Subject: Austar Coal Project (08_0111)

I refer to your letter dated 26 July 2010 inviting submissions on the proposal by Austar to modify its development consent (DA29/95) under section 75W of the *Environmental Planning and Assessment Act 1979*.

The comments below will focus on the proposed modification to DA29/95, namely the addition of one extra longwall panel, Longwall A5a (LW 5a5), adjacent to Longwall A5 (Fig. 1.2 in the EA).

FIGURE 1.4

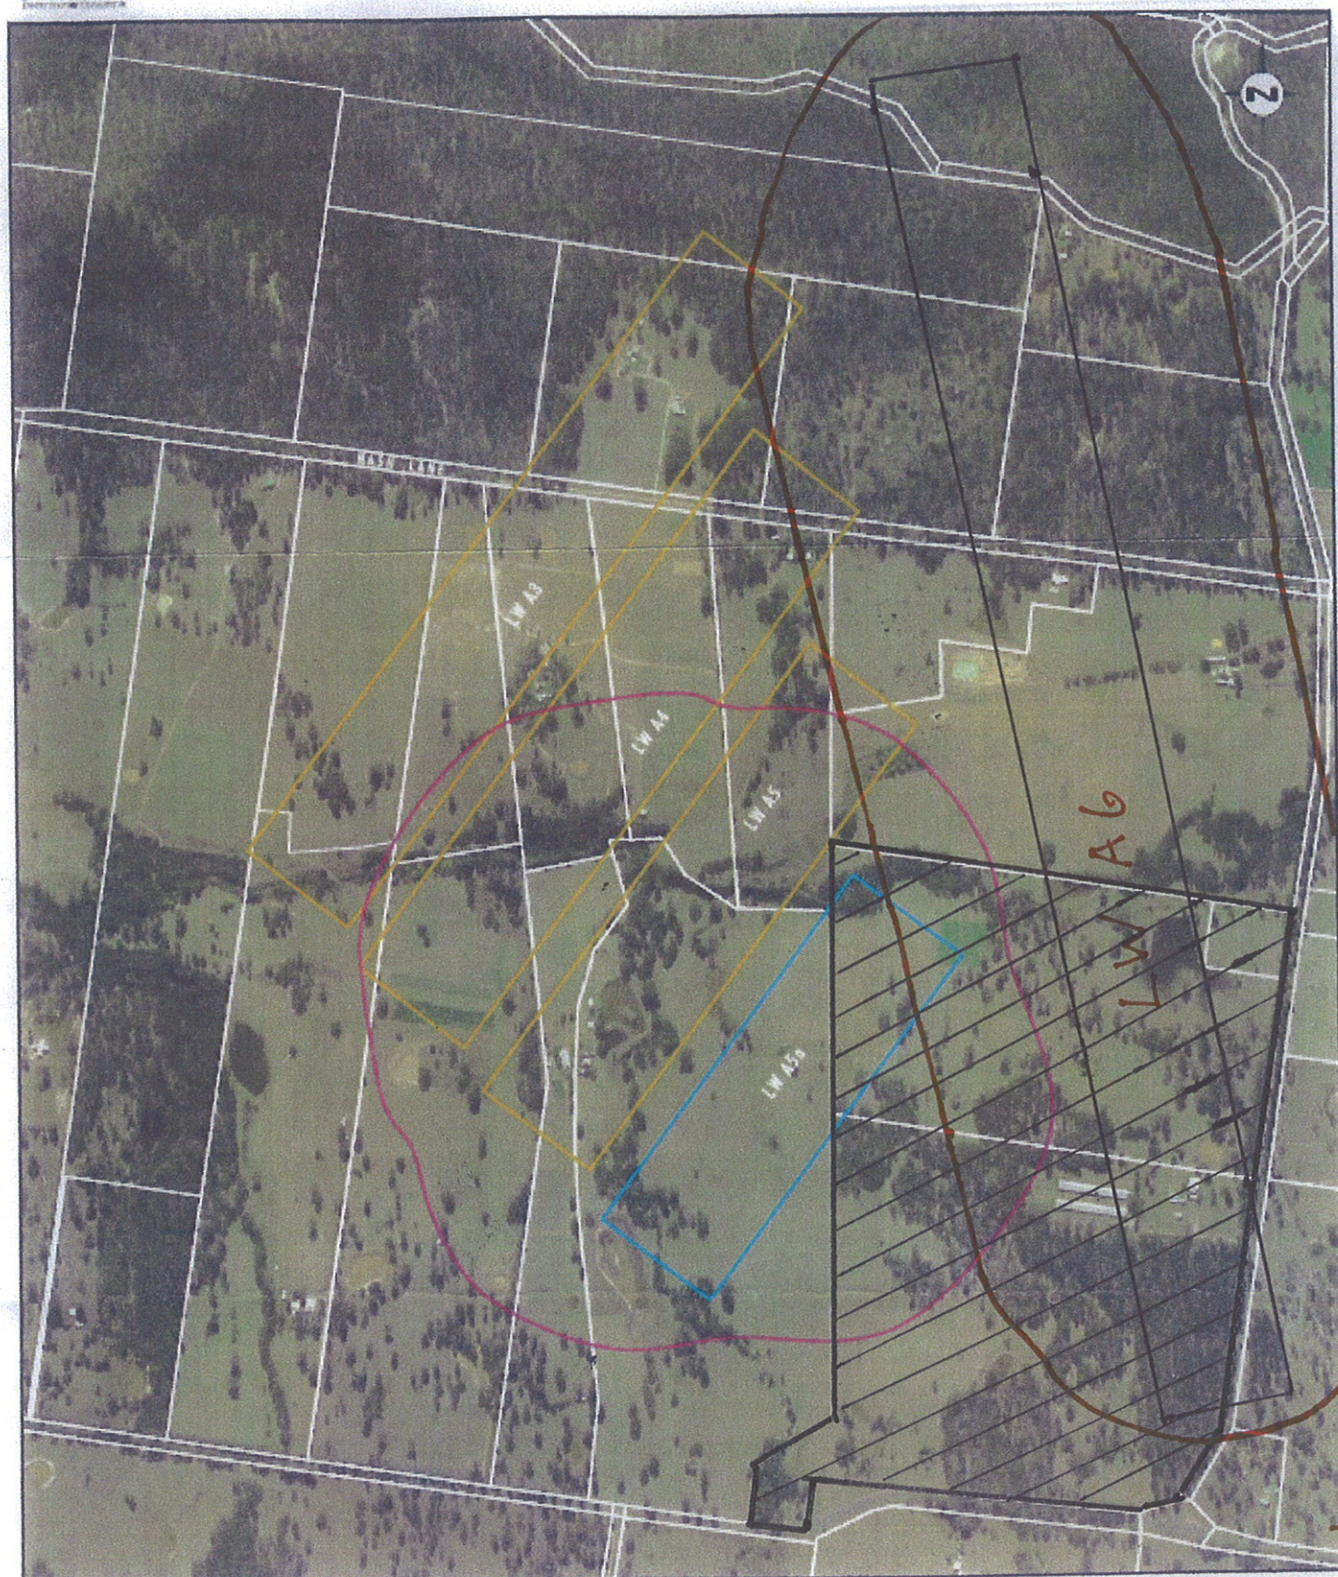
The CMA notes that the proposed modification will increase the maximum allowable extraction height of coal to be mined in this area from 4.5 metres to 6.5 metres. The proposal will also grant approval to the use of Longwall Top Coal Caving (LTCC) technology.

While LTCC methodology will allow for more efficient recovery of the coal resource and increased economic returns, the CMA has concerns regarding the proximity of the underground works to Quorrobolong Creek and Cony Creek. These 2nd and 3rd order creek systems run through the middle and the northern and west/south-western boundaries of the proposal.
